9/02/2019

To: Whom it may Concern  
From: Kevin Curd

Regarding : Rampart Short Row Plat (SP-19-00002)

RAMPART ROW SHORT PLAT APPLICATION

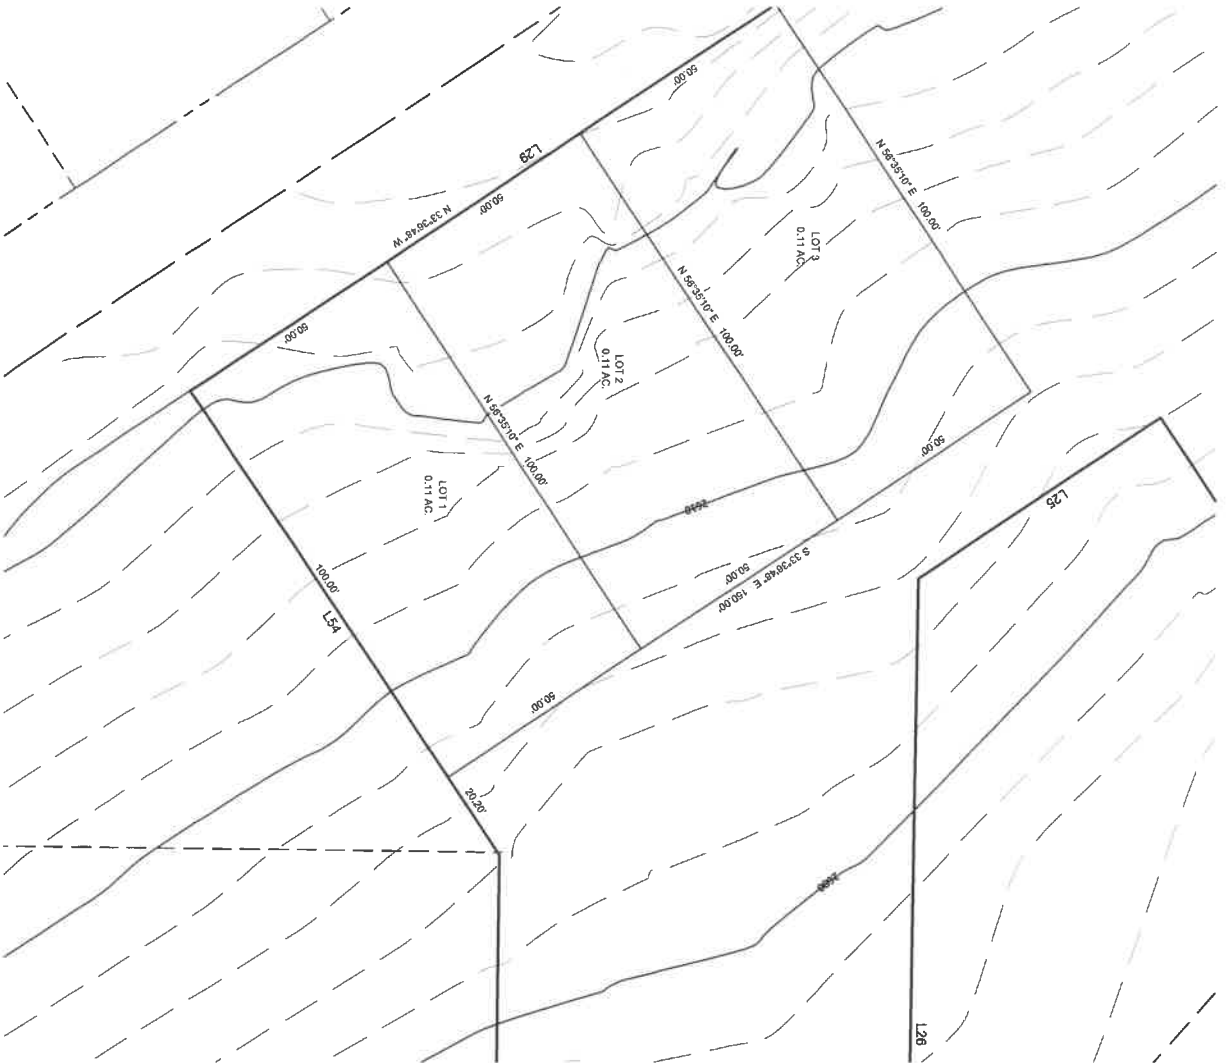
In regards to the three .11 acre subdivisions, I am disappointed that the proposed sites will be smaller than the other lots in the existing development. Currently most existing lots are .16 acres. Most of the current lots are 60 feet wide versus the proposed 50 feet. As the lot size becomes narrower, it becomes very restrictive on the ability to landscape the lots. Also, snow build up between the houses becomes problematic. As these lots front on Rampart Drive, smaller lots can be problematic for snow storage related to plowing Rampart Drive. Will these lots be accessed from Rampart Drive? Fortunately for those currently living at Hyak, the Hyak Estates lot sizing and setbacks has worked well over the years. Unfortunately the county standards fall short of the HPOA setbacks. The 25 foot front setback has given the county snow removal crews a little bit of space to blow snow. On some of the cul-de-sacs, the drawback of a narrower lot becomes readily apparent during normal snow removal where the driveways take up a large portion of the lot. The county snowblower has extremely limited options on blowing snow unless they fill the driveway. Also, the 20 foot separation between houses has worked well to eliminate snow issues with snow coming off rooftops. One only need look to the top of the pass at Summit at Snoqualmie to see the issues presented due to the smaller 10 foot separation between houses. Significant snow damage has occurred due to inadequate side setbacks. With this short plat approval I am afraid that the reduced lot sizes combined with minimal county setbacks will cause snow related issues in the future.

In regards to the overall development, I think the major concerns are parking, snow removal, and ground water mitigation. I have no idea if it is true, but the neighborhood rumor is that the county has already given the developers approval to provide limited car parking and further reduced setbacks. We currently are having issues with the limited parking at Hyak. We have had numerous days where illegal parking on the roads has hampered the ability of emergency vehicles to access the neighborhood. On most winter weekends, all ski area parking lots are full. It shows extremely limited foresight to not provide adequate parking for all proposed new housing units.

As far as water mitigation. I have heard from the developer that they are considering retention ponds to control water run-off. I am concerned that retention ponds would not work in an Alpine environment, and that the sizing of such retention ponds would not be adequate for the large rain events that we experience at the pass. Snoqualmie Pass averages over 400 inches of snow annually. Rainfall/Precipitation comes in at 100 inches annually. Would retention ponds be based only on the loss of permeable surfaces? Does their storm water mitigation plan take into effect that the proposed development sits at the base of Mt. Hyak 3,750 and much of the eastern slope of Mt. Hyak drains through their property. Several houses have experienced flooding issues in the lower Hyak area, and I would hope the loss of permeable surfaces and change in drainage patterns would not exacerbate the ground/surface run-off issue.
